**Notice pursuant to: Section 177AE of the Planning and Development Act 2000 (as amended) and the Planning and Development Regulations 2001 (as amended) Improvements to Public Realm to Bridge Street and lands to the rear and side of The Grain Store, John's Street, New Ross, Co. Wexford**

**Notice of Planning Application to An Coimisiún Pleanála for Approval.**

Submission from Kenneth & Juliet Rogers

Site Layout Plan (Area 2) As Proposed

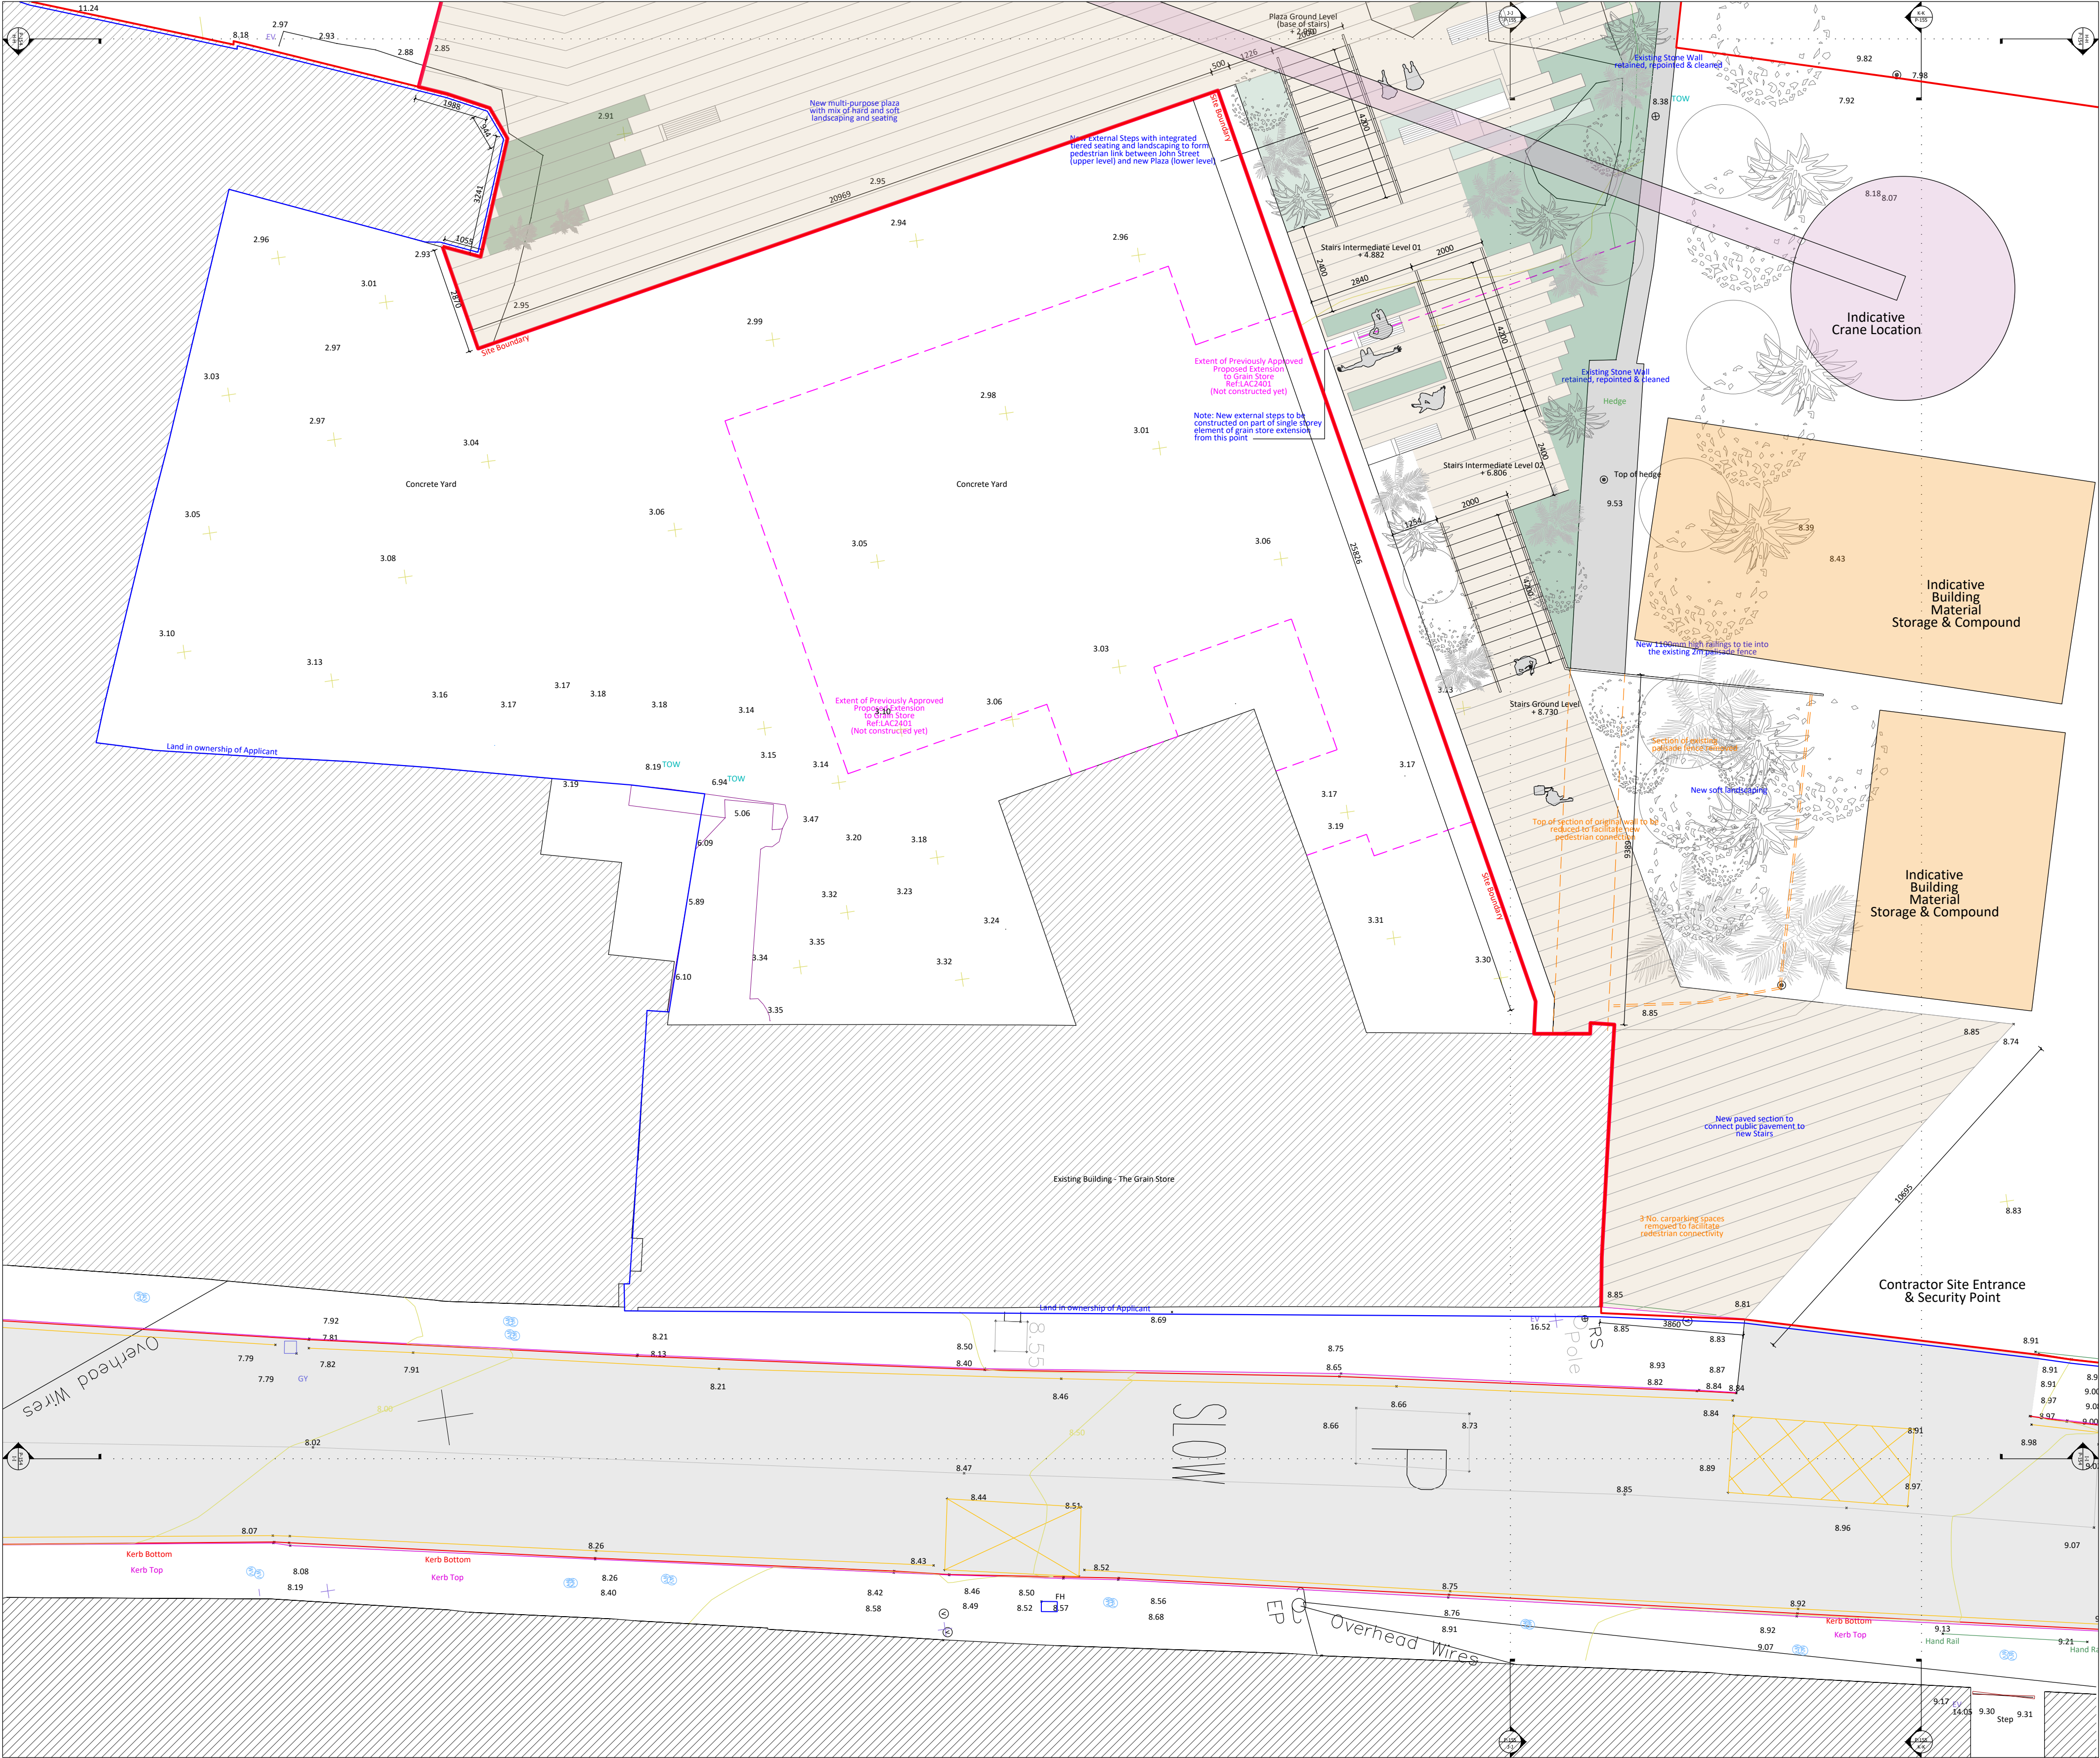
**4. Partial demolition of section of the wall between Bridge Street (abutting No.2 Bridge Street) to facilitate new connecting gently sloped pedestrian access route to new Plaza area in current yard. The new access route to be provided with solid guarding and walls with planting and seating.**

Drainage for surface water and a relief exit, under the current wall into the adjacent deep drains, needs to be preserved. I would suggest that pipe work to include a non-return valve, directly into the river, would reduce the risk of flooding from rainwater to my surgery premises due to the steep gradient of the street. Flooding from surface water has happened in the past (see attached images)

There are 2 live deep drains in this area which take both surface water from our yard and rainwater from our building. Access and maintenance of these drains is very important keeping in mind that these will now be located under the ramp.

01 Section A-A As Proposed (Elevaiton to Riverside)
Scale: 1:100

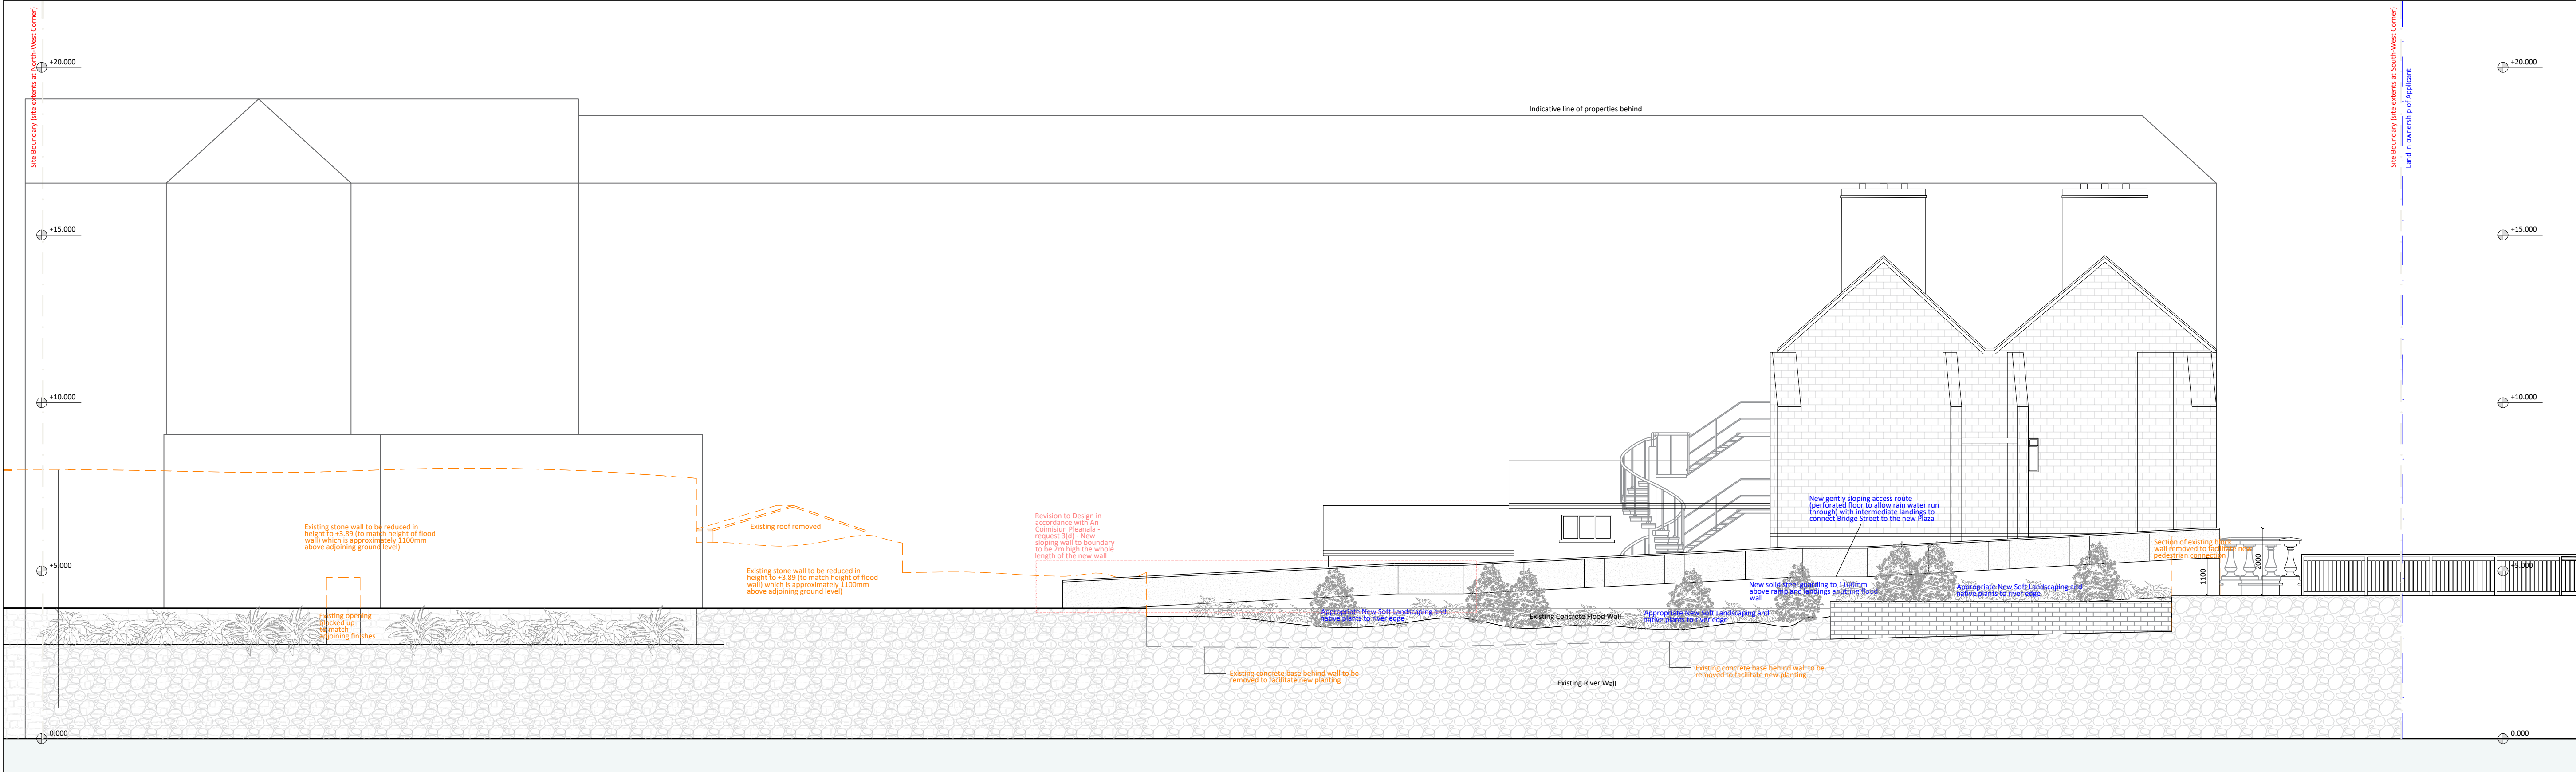
**7. Lowering stone wall between the yard area and the river and between proposed plaza and rear of properties on Bridge Street to 1100mm above ground level.**

The wall height along the ramp (1100mm) adjacent to my property is of major concern. The proposed sloping wall will expose the rear of my premises significantly. This area which is currently private would then be exposed to the public.

I request that the wall height along the ramp be consistent in height in its entirety. I suggest that this should be a minimum of 2.75 meters with no taper or gradient.
